December 23, 2014
06267

Application for Level 1 Site Alteration
Proposed Parking Lot Expansion

We have reviewed the staff comments emailed on December 11, 2014 and offer the below responses:

PRE-DEVELOPMENT DRAINAGE PLAN
SCALE = 1"=20'

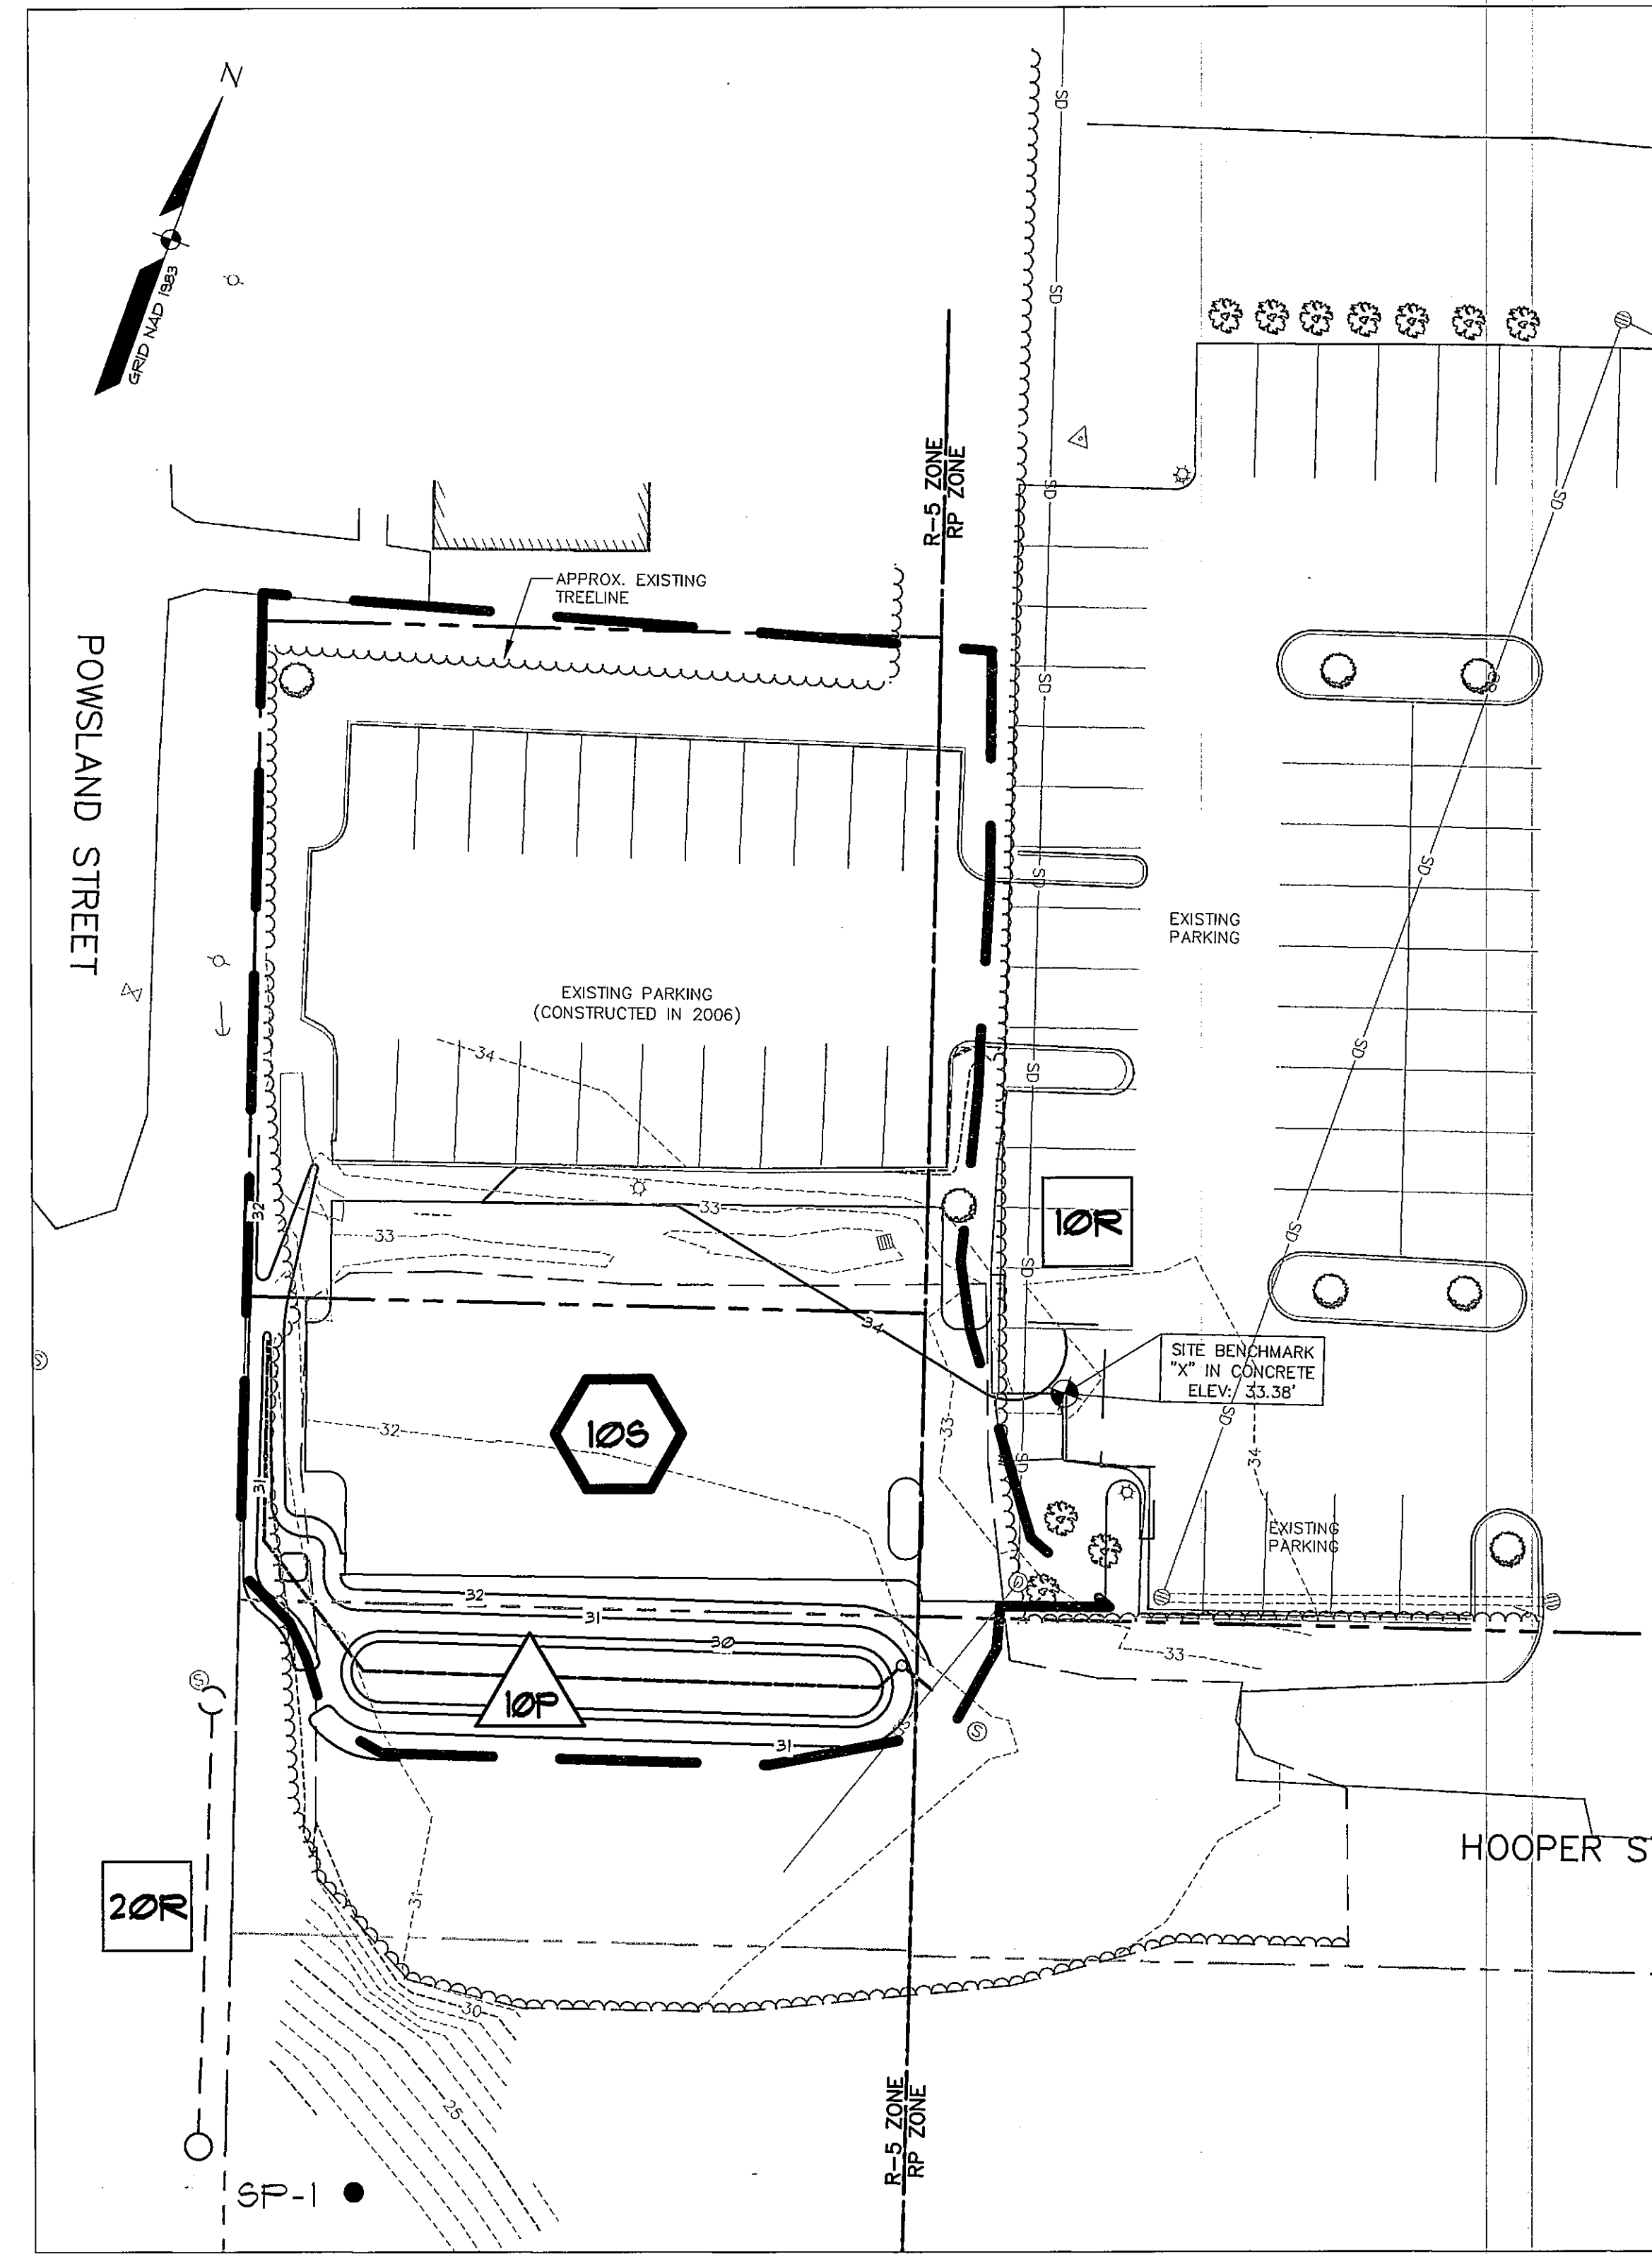
Cumberland County and part of Oxford County, Maine was used to develop the HydroCAD model. The soil survey indicates Hydrologic Group C Belgrade soils in the general development area. A drainage plan was created to illustrate the different watershed areas, reaches and ponds in the pre- and post-development conditions. Flows paths are assumed negligible because sheet flow mainly occurs over paved and gravel surfaces, therefore no TC paths are shown in the drainage plan and direct entry (5 minutes) was used. Also, the 24" RCP that outlets to the "swamp" pond was assumed to have 10 CFS base flow (Half full) since the project in pre- and post-development conditions ties into the closed storm drainage system at downstream in the overall watershed.
